4th November 2019

Written representation on behalf of Mrs Agnes Patricia Engelen in response to the Rule 6 Letter dated 15th October 2019.**Site: Court Close Farm, Portsmouth Road (A3), Cobham, Surrey KT11 1EN**

I have set out below a series of points discussed with my client regarding the proposed temporary and permanent rights and acquisitions as a result of the proposed M25 JCT 10/A3 Wisley Interchange Improvement.

Drawing Title: **LAND PLANS REGULATION 5(2)(i) SHEET 7 OF 31**

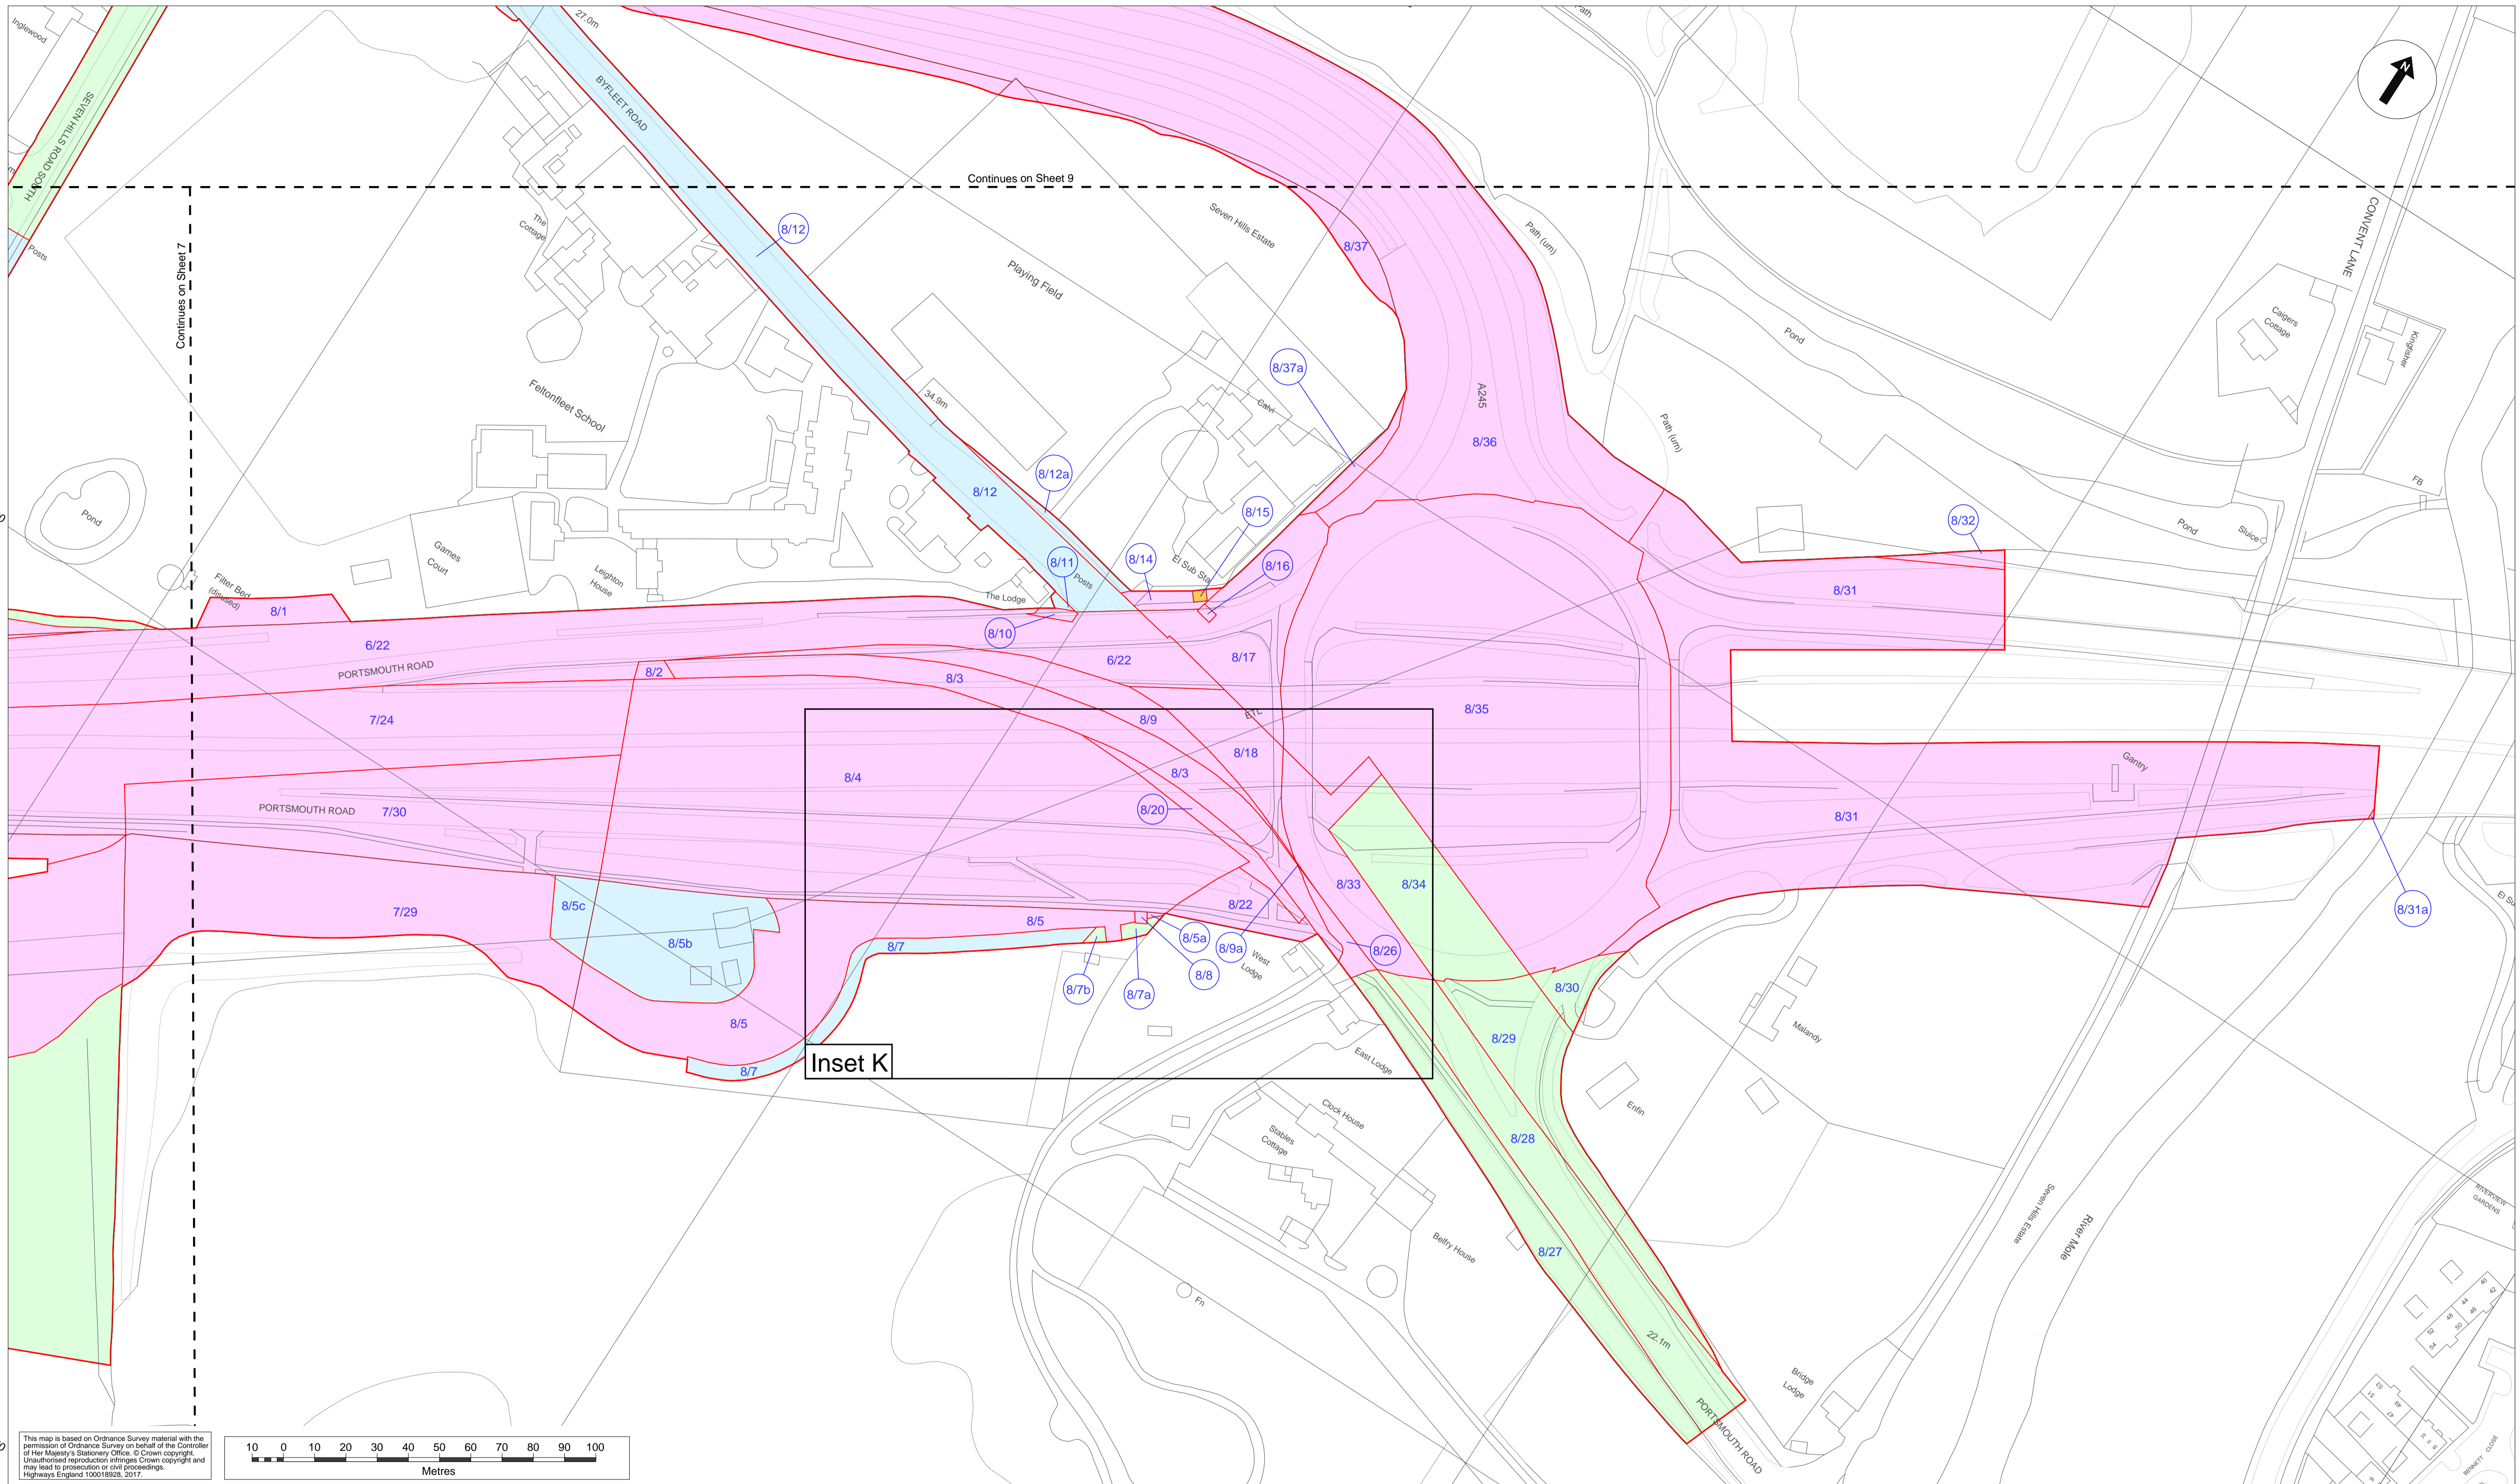
- Details to be provided for provisions of a new fence to be installed and maintained by Highways England along the newly proposed highway boundary.
- We require full details for the road width and proposed construction methodology for land to be used temporarily and rights to be acquired permanently identified on the Land Plans Regulation 5(2)(i); Sheet 7 of 31.

A gas pipe needs to be diverted through my land and an easement will be required to document this. I need to know what width this will be, as the plans look to have this wider than may be required. Additionally, the diverted pipe route is also identified as a permanent right of access. I need to know whether this relates to the gas pipe only or whether there are any further rights being sought for gantry maintenance. No details have been provided to date as to the what this will consist of (width, material construction & maintenance responsibilities). I do not want a fully constructed road/track to break up the field and would prefer a means of construction that could accommodate a grass finish (with appropriate sub-layer). Neither do I want to be responsible for the future maintenance of any access which is only required as a direct result of this scheme.

- The proposal includes a series of amendments to my existing drive layout. The construction details for this and the specification will need to be provided for agreement. As part of this, there appears to be a turning head included at the bottom of the drive, which had not been mentioned in any prior discussions and to my mind is not necessary. I would anticipate that the requirement to rely on maintained access rights would be limited. And therefore, the need for further impact on the [REDACTED] concern.
